**Date:** 12/12/2023

**Re:** Framing items  
Location: Lot 172 The Farm at Neill:p:s Creek (Lillington, NC)  
JDS Project No.: RDU2311934  
Date of Inspection: 12/12/23

Drawing file: SFD2303-0092 / 172 Floor Layout Revised.pdf

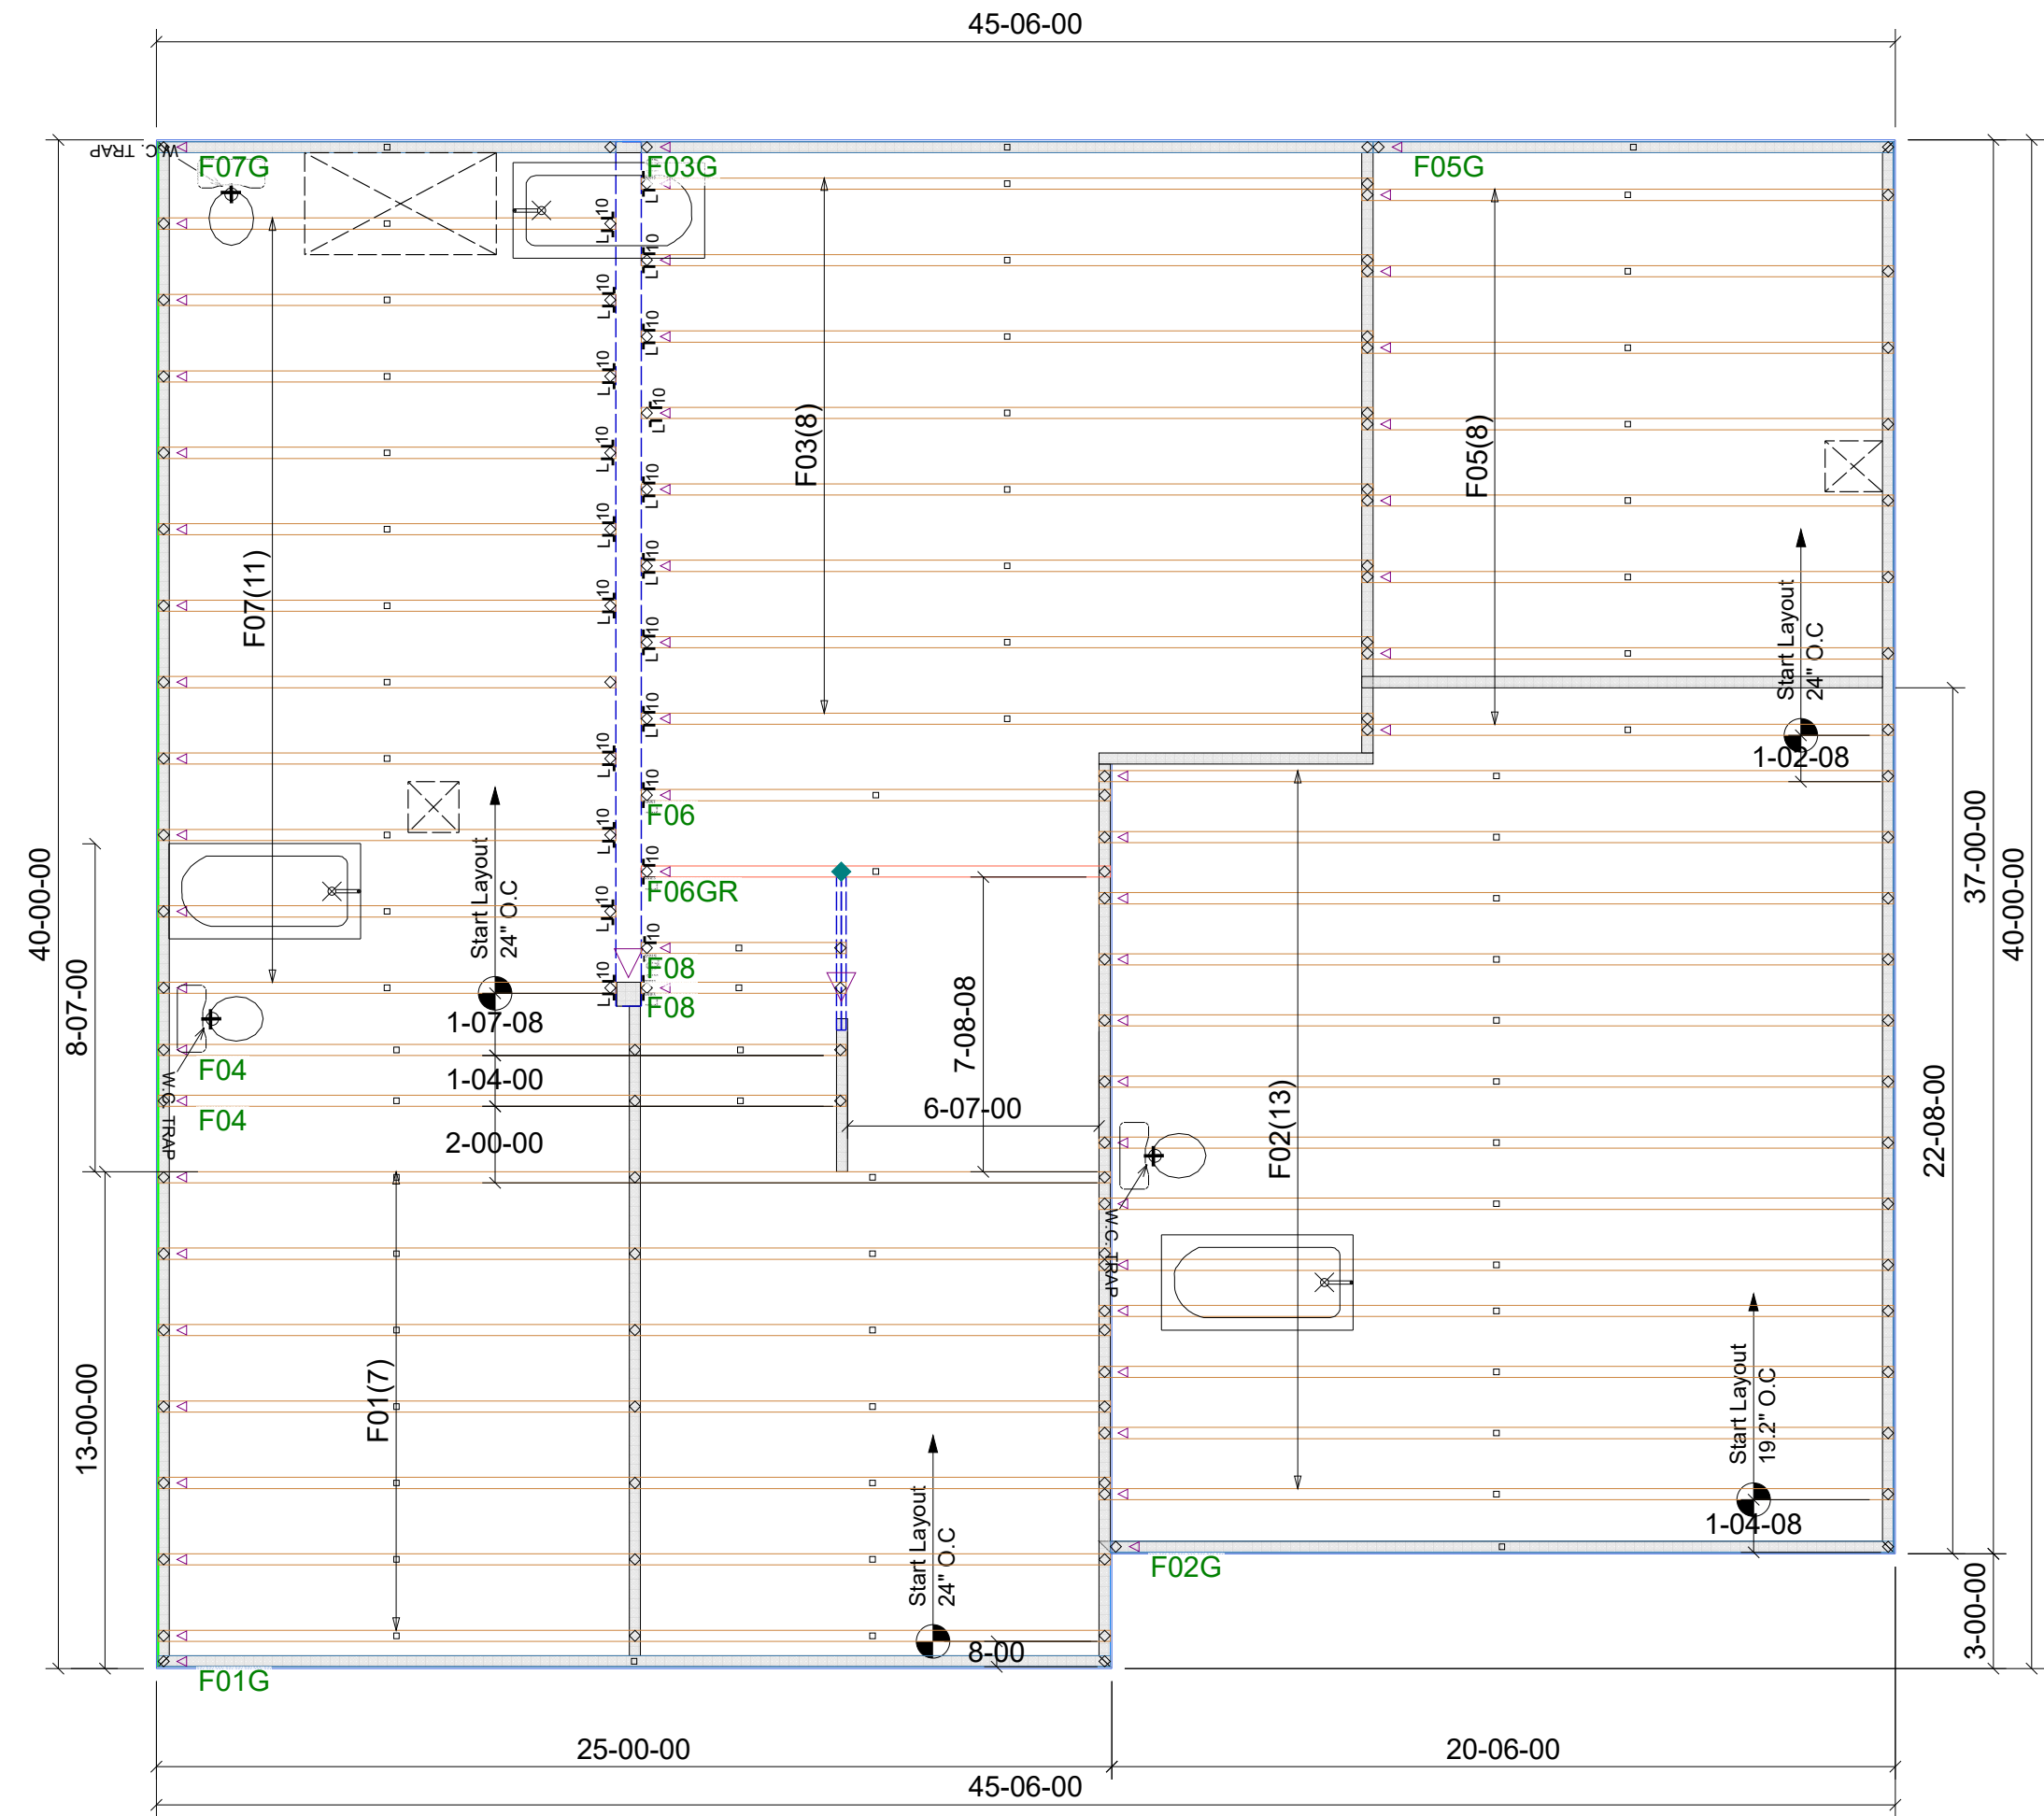
The client has requested evaluation of the 2<sup>nd</sup> – 10<sup>th</sup> through bolts for the W10x45 steel beam aligning directly with F07 floor trusses above the kitchen. The floor truss placement causes no visibility of the through bolt fastening condition.

Based on our onsite observation and review the contractor shall install (1) 1/2" through bolt within 6" of each effected through bolt to allow a visible bolt fastening condition. Ensure the newly placed through bolts do not exceed a maximum spacing of 24" O.C.
